DOC17/559330-01  
SSD 8388

**SSD 8388 – MACQUARIE UNIVERSITY ARTS PRECINCT – ENVIRONMENTAL IMPACT  
STATEMENT (EIS)**

I am writing to you in reply to your invitation to the NSW Environment Protection Authority (EPA) to make a submission concerning the above project EIS.

Figure 1: Aerial photo of the area illustrating nearest sensitive receivers and noise measurement locations

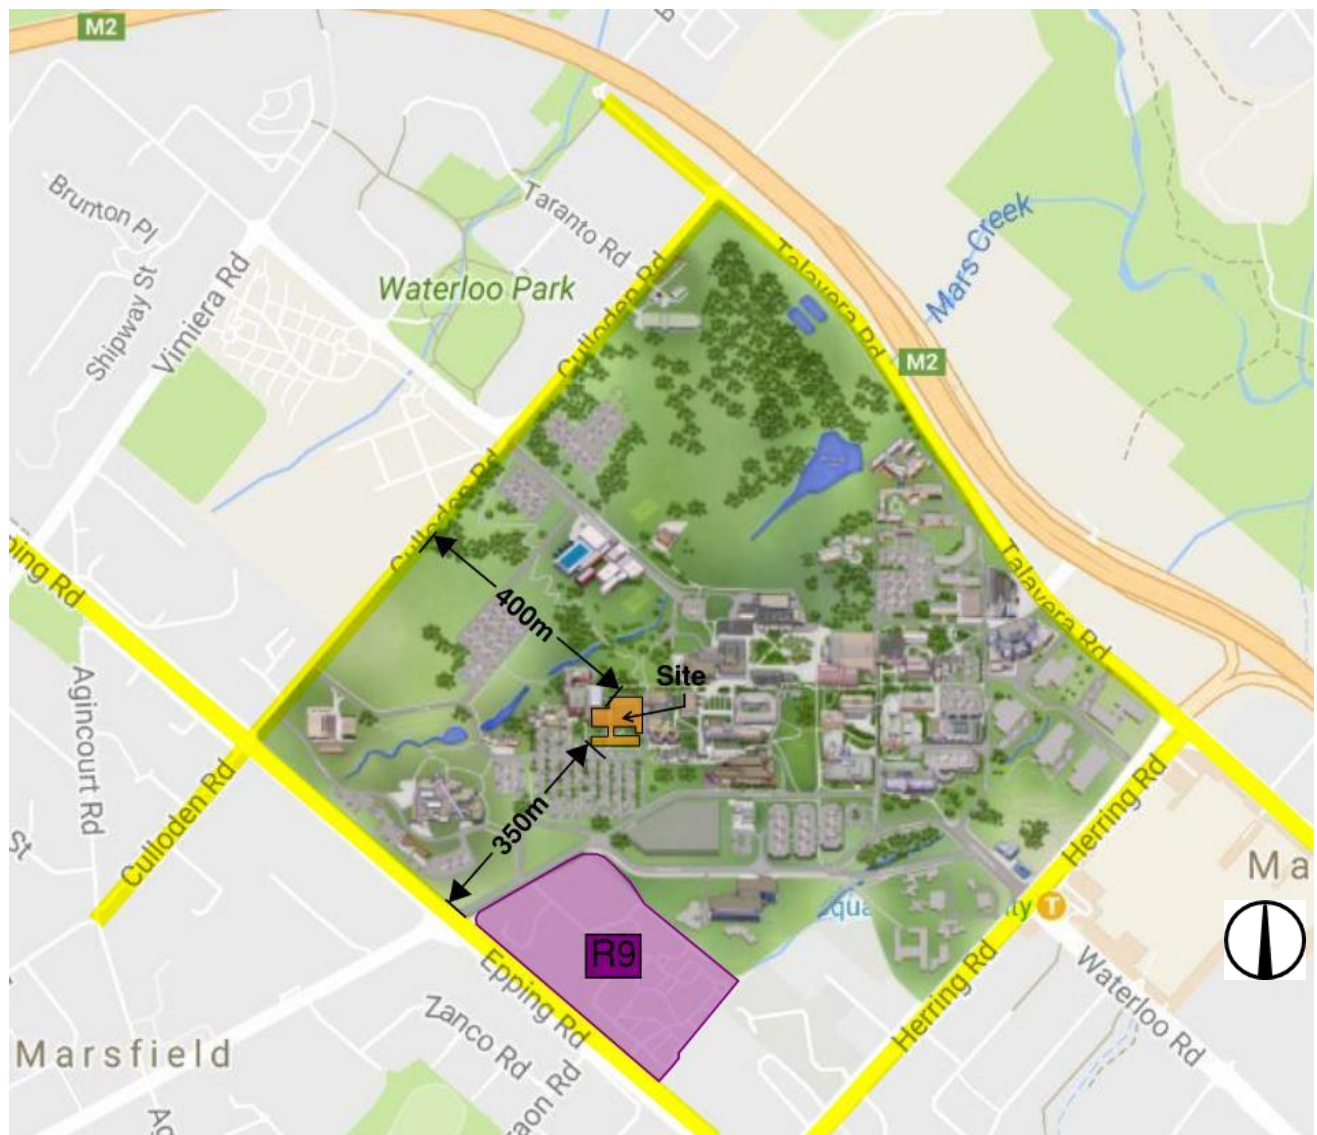
The EPA is concerned that monitoring to establish background noise levels was not undertaken consistent with the guidance material provided in the INP. For instance, Figure 2 to EIS Appendix S shows that background noise measurements were erroneously undertaken within the University campus rather than at the most affected off-campus noise sensitive receivers. The EPA anticipates that the background noise measurements would have been affected by on campus noise sources near the monitoring locations shown in Figure 2.

- (a) at the most affected off-campus noise sensitive receivers, including Baptist aged care centre off Balaclava Road, and in accordance with guidance material in the Industrial Noise Policy, or
- (b) to adopt a deemed night period background noise level of 30 dBA.
